Address: 1670 Forest Ln.

CHECK-LIST AGAINST ZONING ORDINANCE

permit number: 2014-02072

Proposed Use/Work - Split lot off from existing lot.

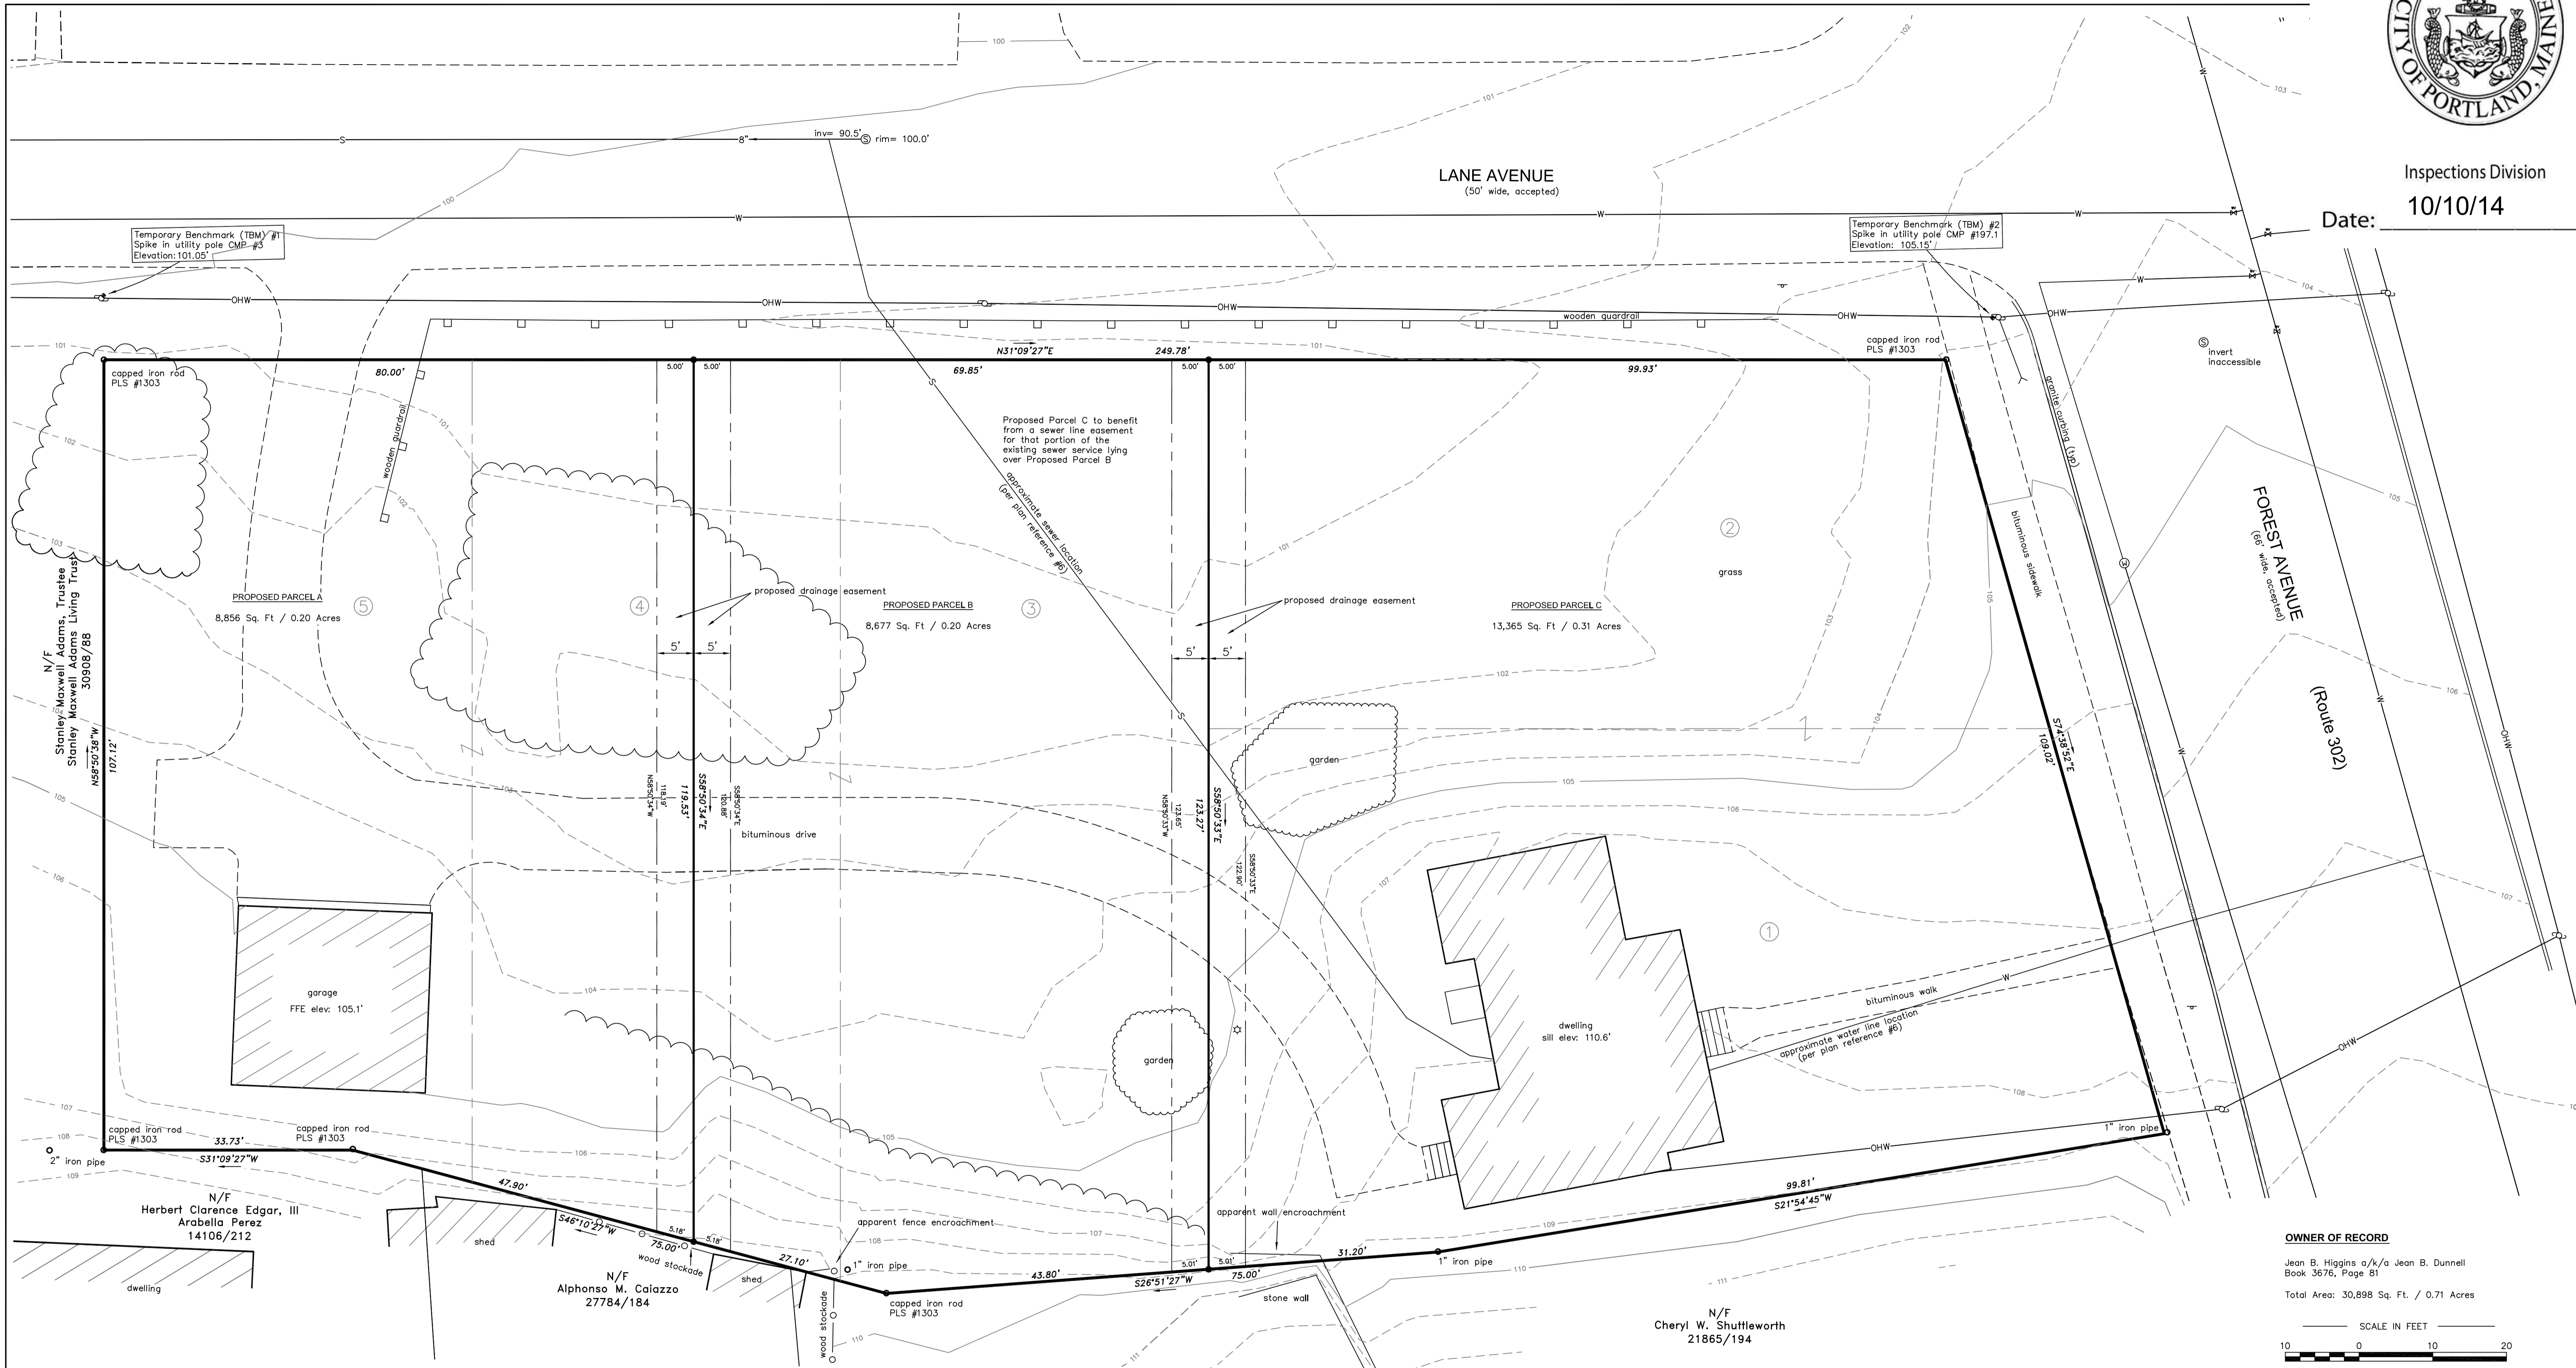
\* Off-street Parking - need to show two parking spaces -- two shown beyond 20' side yard on side street on driveway plan site plan
